The Parish Councils of Assington, Bures St Mary, Leavenheath, Little Cornard, Polstead & Stoke by Nayland

Response to the Applicant's reply to the Parish Councils' Deadline 6 submission regarding proposed works in Sections D/E & F

STOUR VALLEY EAST  
 CABLE SEALING END  
 COMPOUND AT LITTLE  
 CORNARD

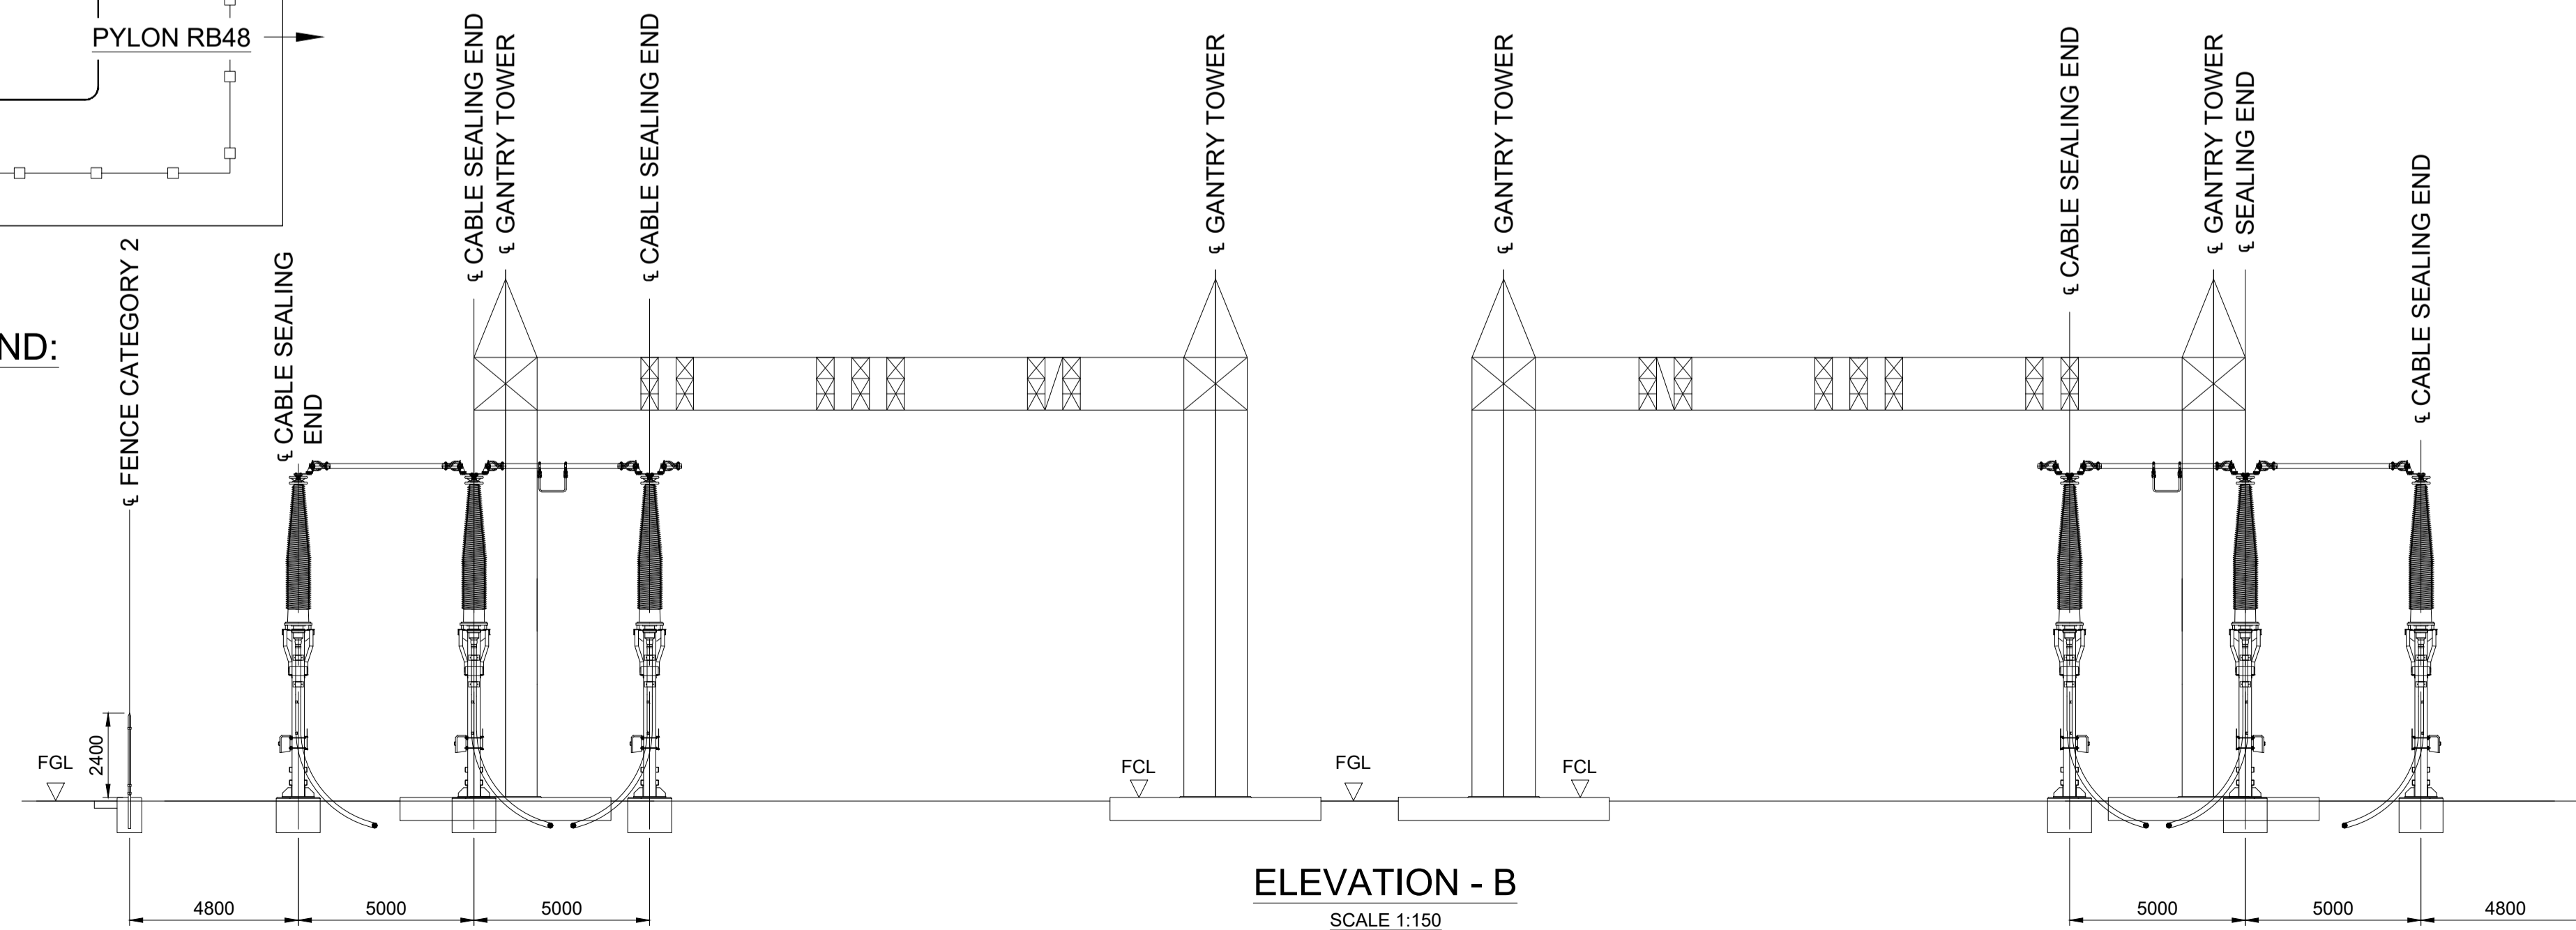
- 4.1 The Applicant reiterates its previous position that the proposal is not yet sufficiently detailed to warrant modifying the proposal at DCO stage. The Applicant appears to have ignored our central point that this is not a landscaping/mitigation/design issue to be addressed at a future date via commitments in the REAC and subject to yet-to-be-completed detailed designs. This is an access road alignment matter and relates to the selection of appropriate private land over which powers are to be granted for the provision of an access road of significant length.

- 4.2 In the absence of challenge to the substance of our proposal – that the current road alignment harms long views from the Stour Valley Project Area and therefore also its setting – we contend that this concern is sufficiently material to justify consideration at this stage and over which we ask the ExA to recommend a specific amendment to the scheme in response to local consultation requests.
